RE: REVIEW OF THE AMENDED ROCKY HILL COAL PROJECT ENVIRONMENTAL IMPACT STATEMENT (SSD 5156)

I refer to your email dated 12 August 2016, seeking comments on the exhibited Amended Rocky Hill Coal Project Environmental Impact Statement (EIS) located approximately five kilometres south-east of Gloucester in the MidCoast local government area.

ATTACHMENT A: OEH REVIEW OF THE AMENDED ROCKY HILL COAL PROJECT ENVIRONMENTAL IMPACT STATEMENT (SSD 5156) GLOUCESTER

Figure 2.13.1 Predicted Change in Peak Flood Levels, 1 in 100 AEP Event near Private Haul Crossing of Waukivory Creek

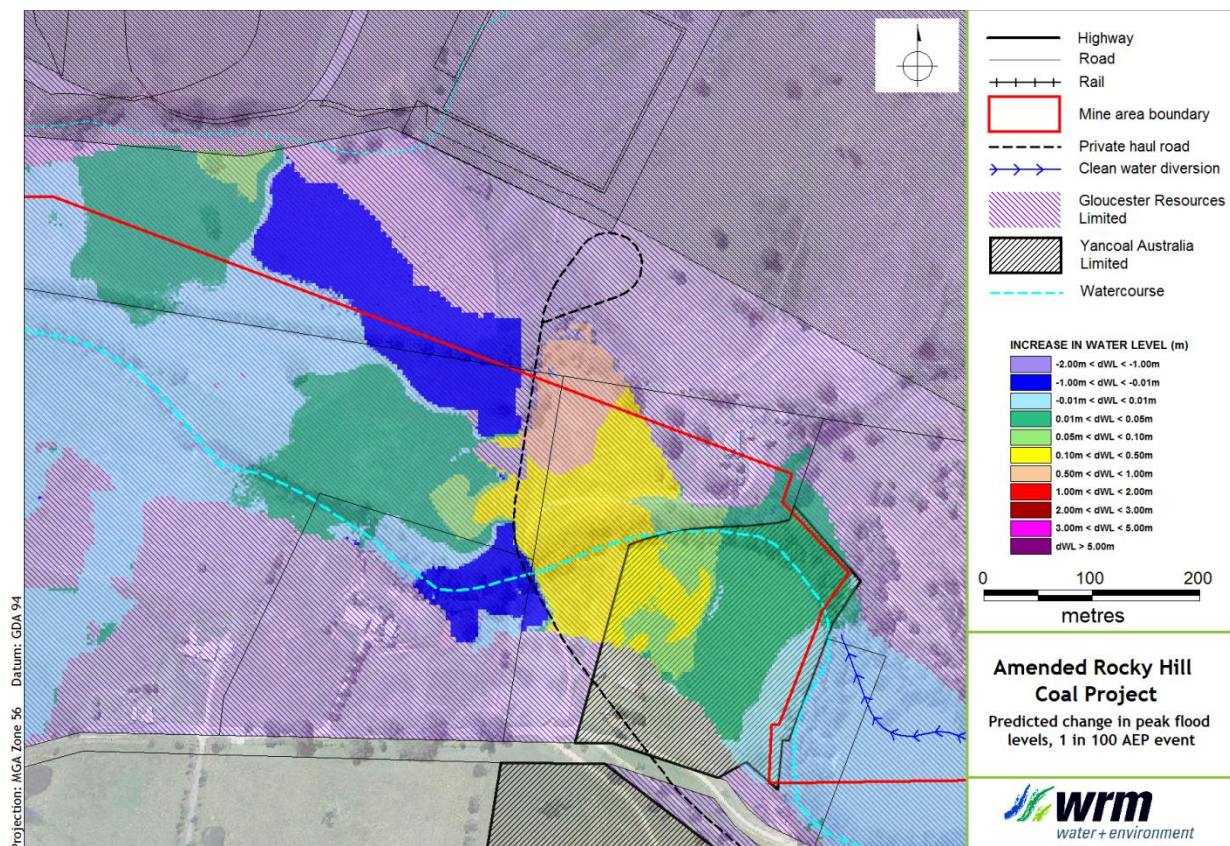
- increases in flood level at the northern end of the proposed private haul road in the vicinity of the Waukivory Creek crossing. These increases include magnitudes of 0.5 to 1 m increase in level and up to 2 m/s increase in velocity. The increases in this area were not present on the previously approved scheme. There is also lack of clarity in the documents with mapping of boundaries appearing inconsistent with statements regarding ownership of the affected land

Prior to issuing of consent conditions confirmation of land ownership in the vicinity of the Waukivory Creek crossing is required. If this land is privately owned land demonstration of negotiation and compensation of affected owners would be required. The impact indicated by the WRM study is considered significant and OEH cannot endorse activities with significant impact on private land holders.

- 3) Detailed design of the Waukivory Creek crossing should include update of the flood analysis to ensure final design configuration is modelled. Bank protection works will be required to be incorporated in the design to accommodate the increase in velocity in this area. Impact on

private property is to be minimised and appropriate negotiation and compensation should be carried out as part of the detailed design phase.
